Our Ref: AWE200083-L01: BCP/bcp
Contact: Dr Brett C. Phillips

22nd February 2021

RESPONSES TO FLOODING SUBMISSIONS, ASPECT INDUSTRIAL ESTATE, KEMPS CREEK, NSW

Figure 19 5 yr ARI Velocity Differences - (Stage 1 Conditions – Benchmark Conditions)

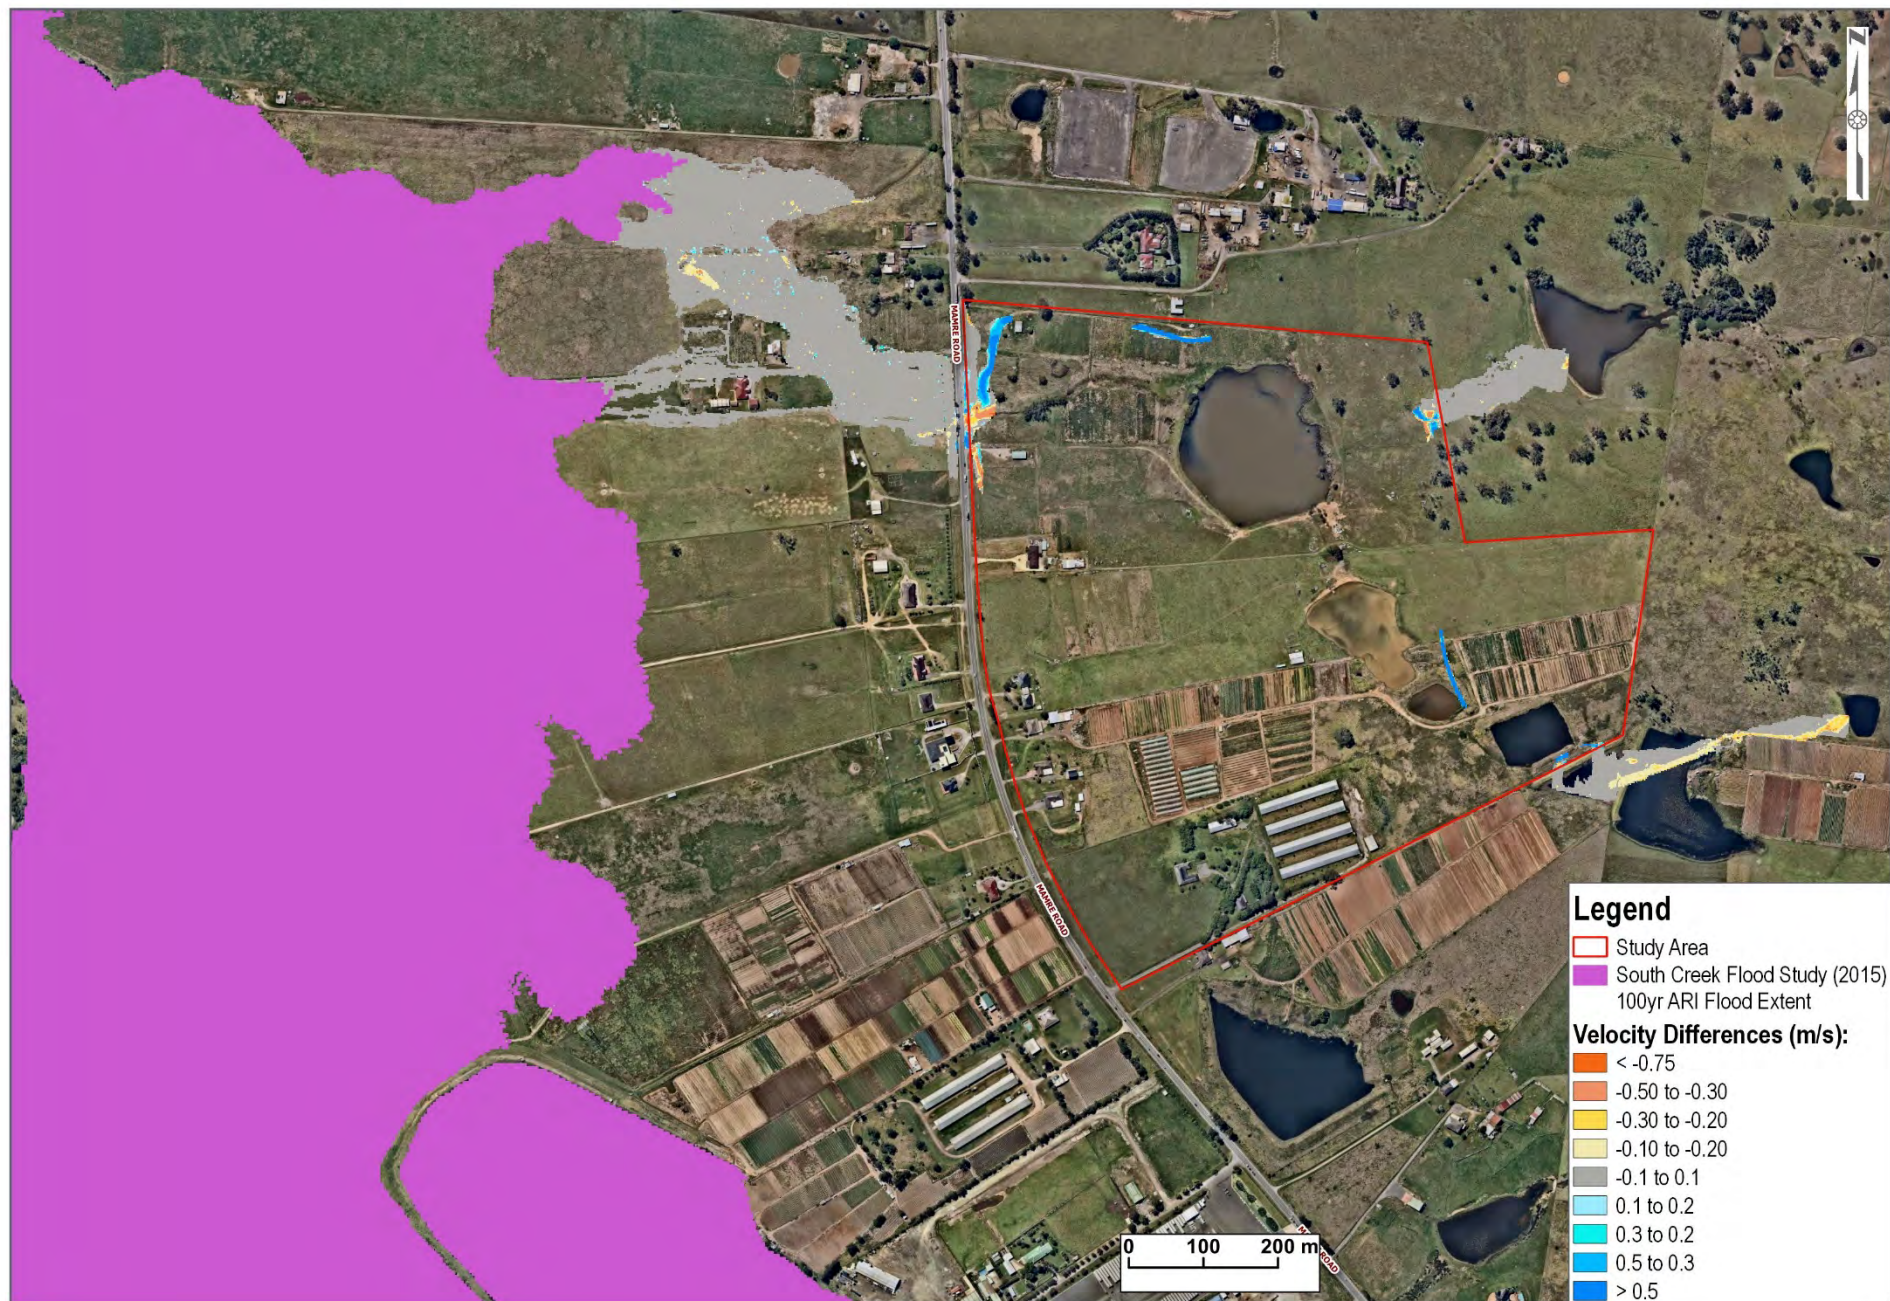
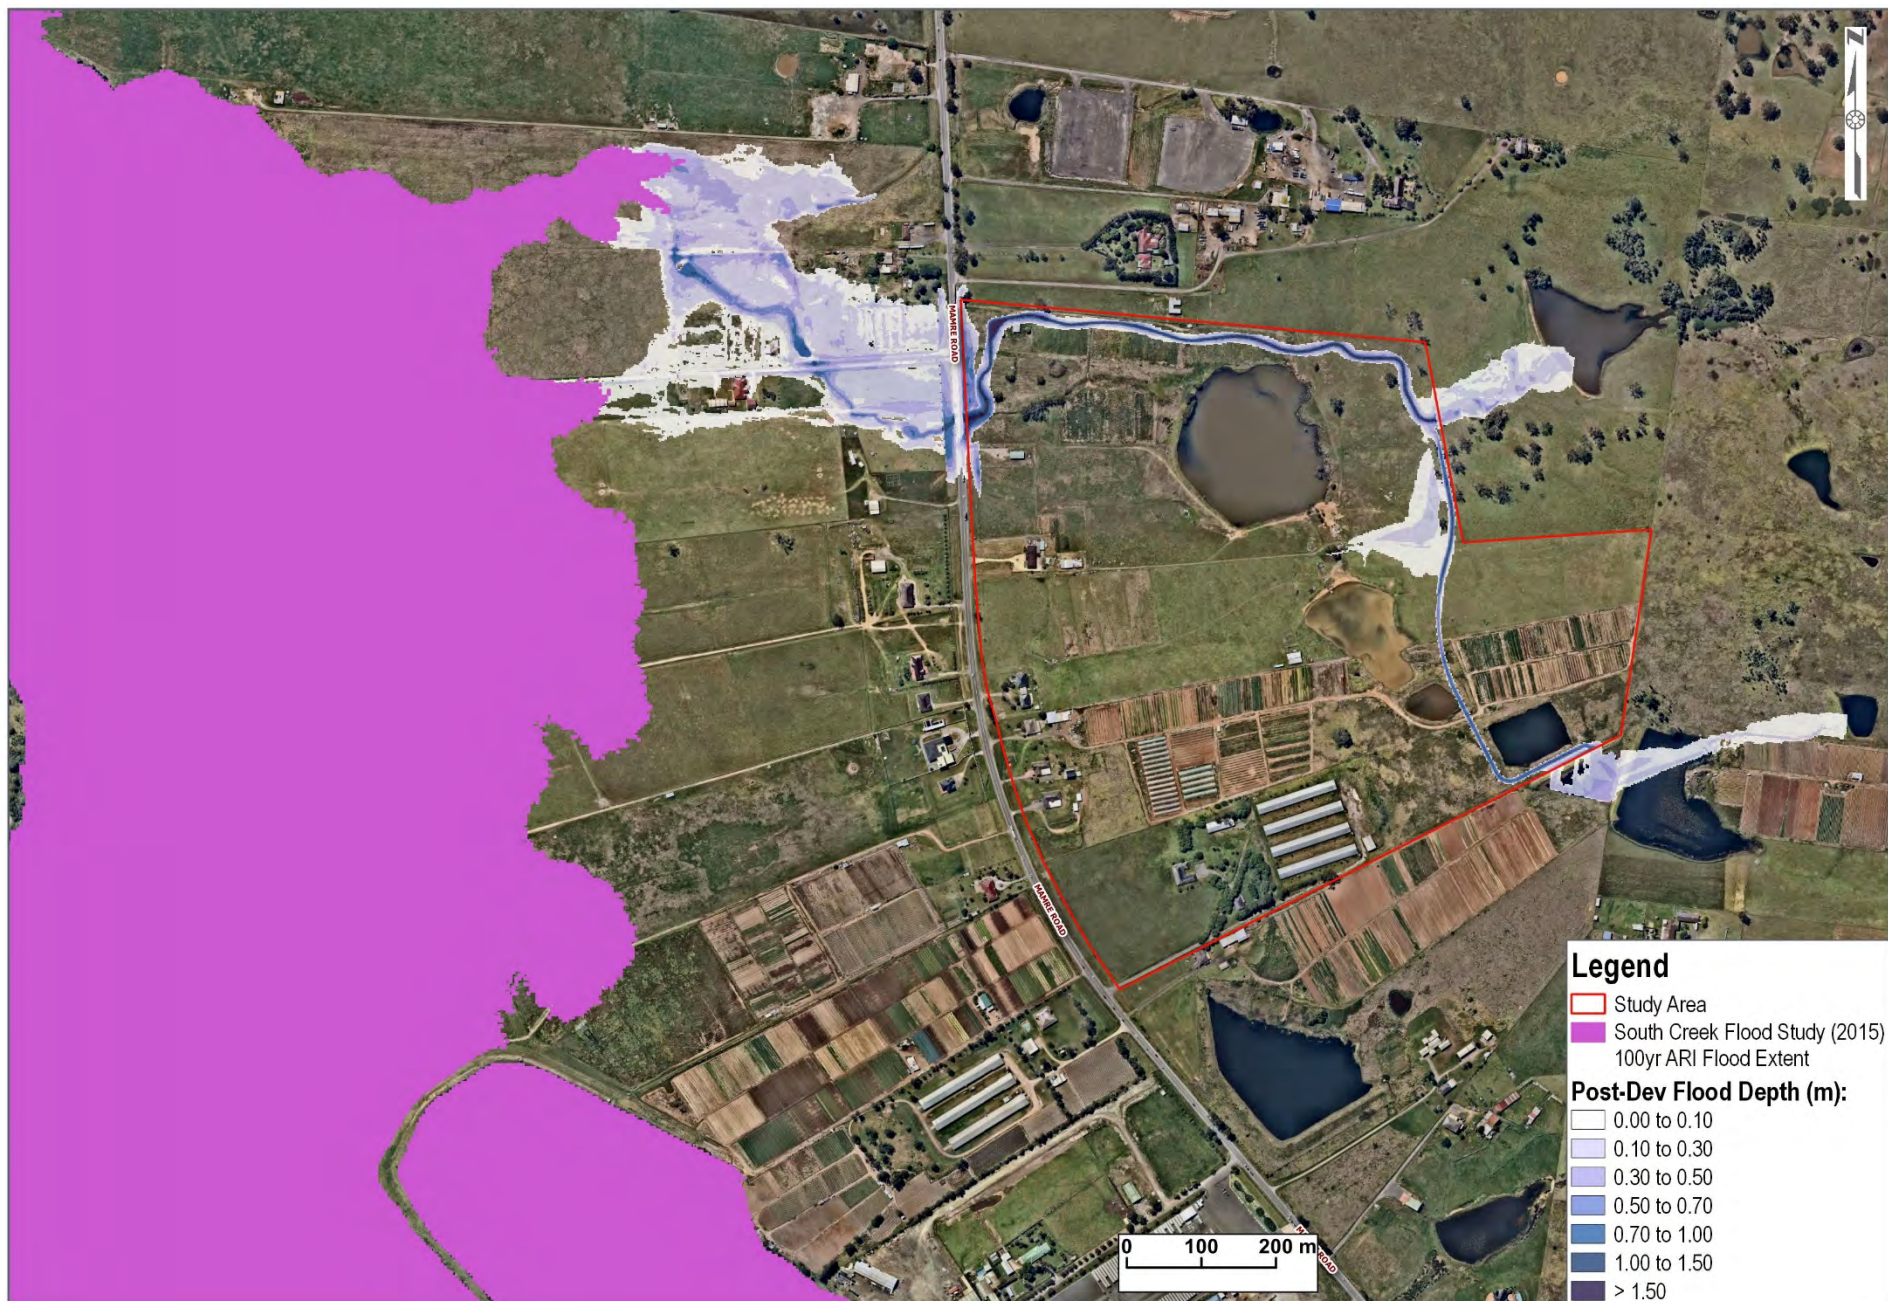
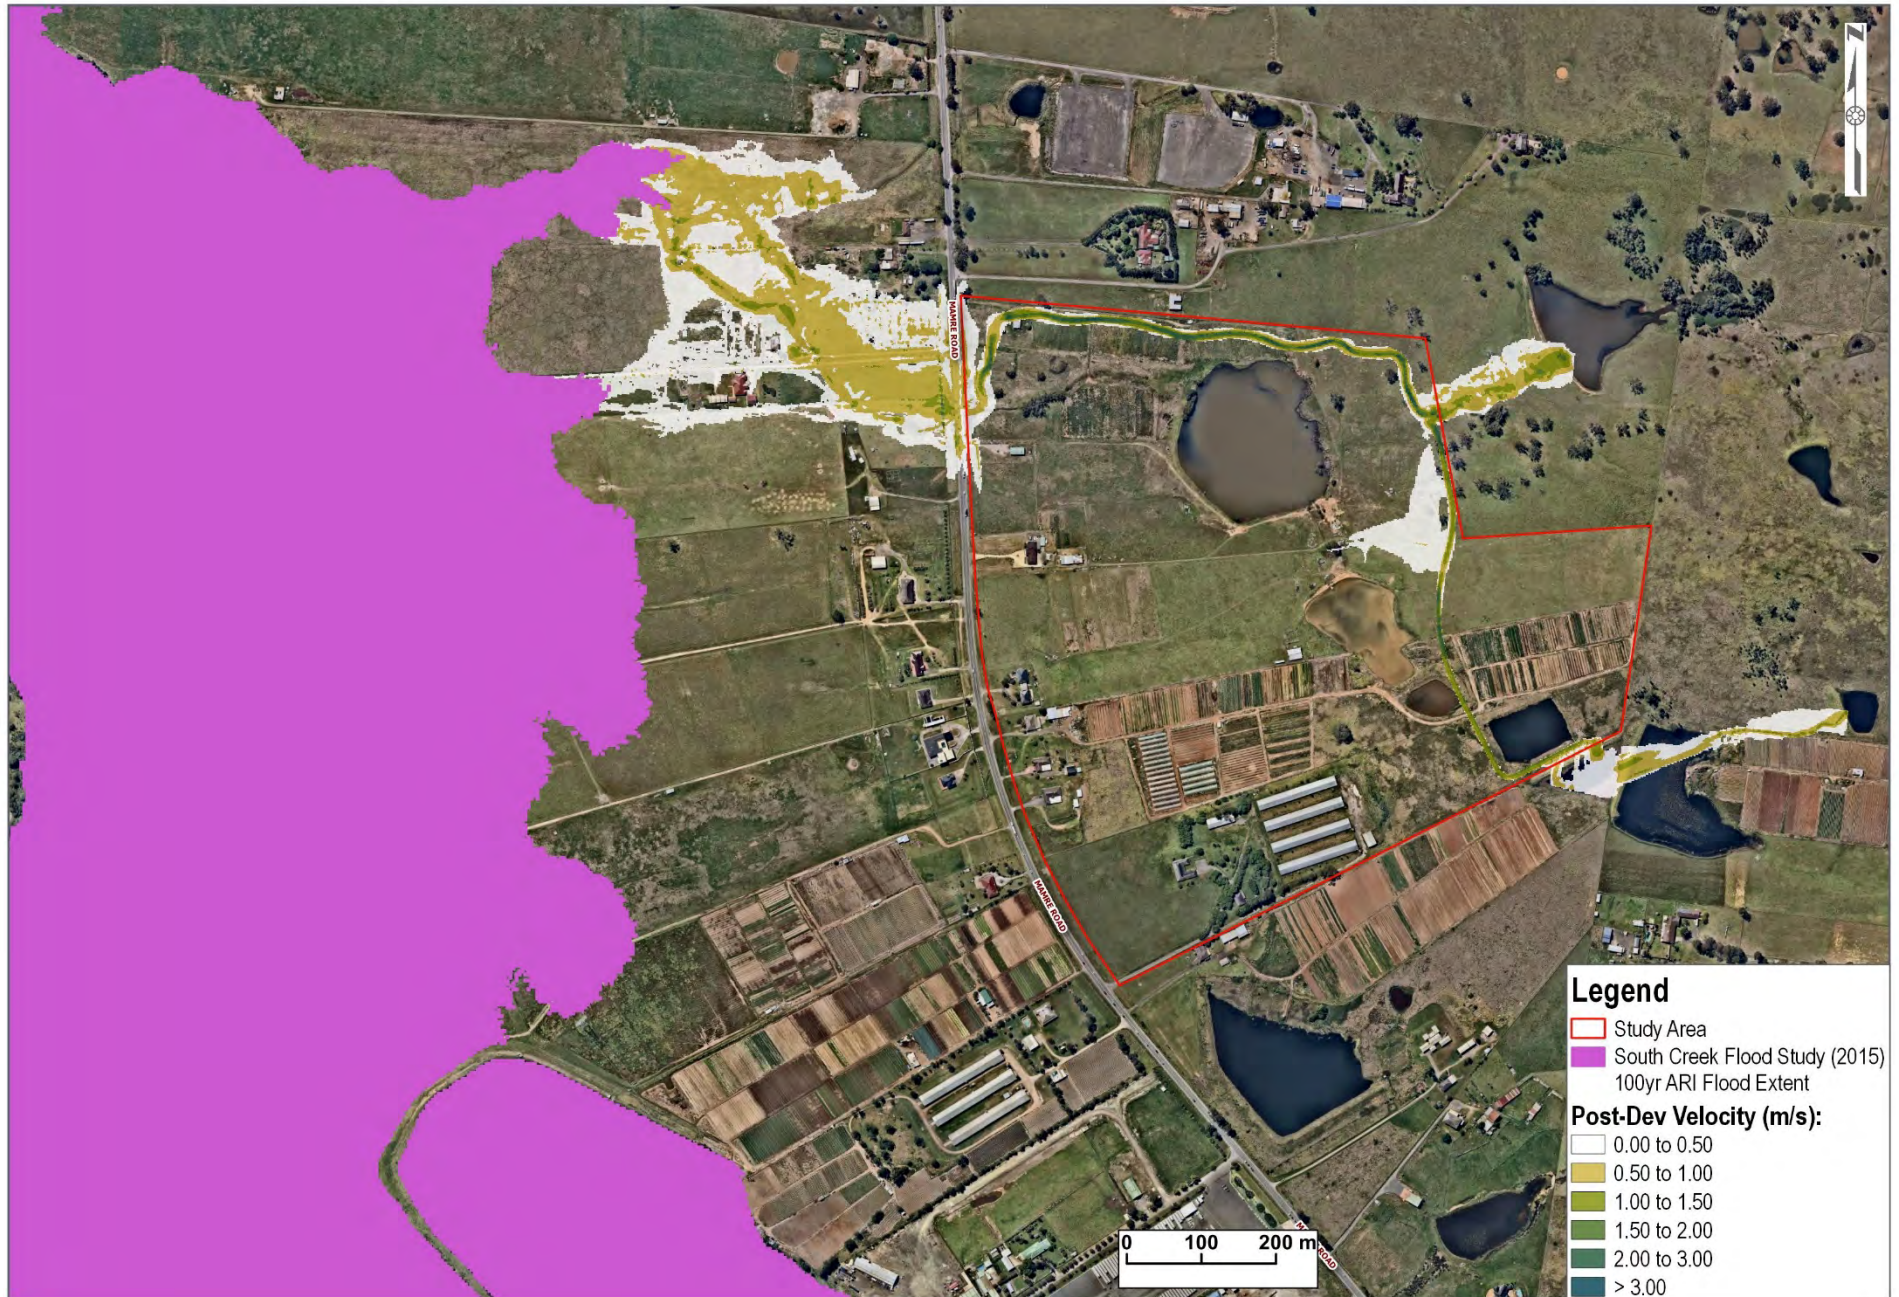
- *The developed scenario maps present local overland flow for Stage 1 which comprises of two industrial lots on the northern part of the site. However, from a flow management perspective, an overland flow study should consider the ultimate developed scenario of the site instead of considering each progressive development independently.*

- *All maps for developed conditions should properly depict the layout of the development, locations of proposed constructed channels and the location of the proposed detention basin.*

The final masterplan has been assessed and the results of the assessment have been incorporated into an updated version of the FIA report.

The updated Figures have been incorporated into an updated version of the FIA report.
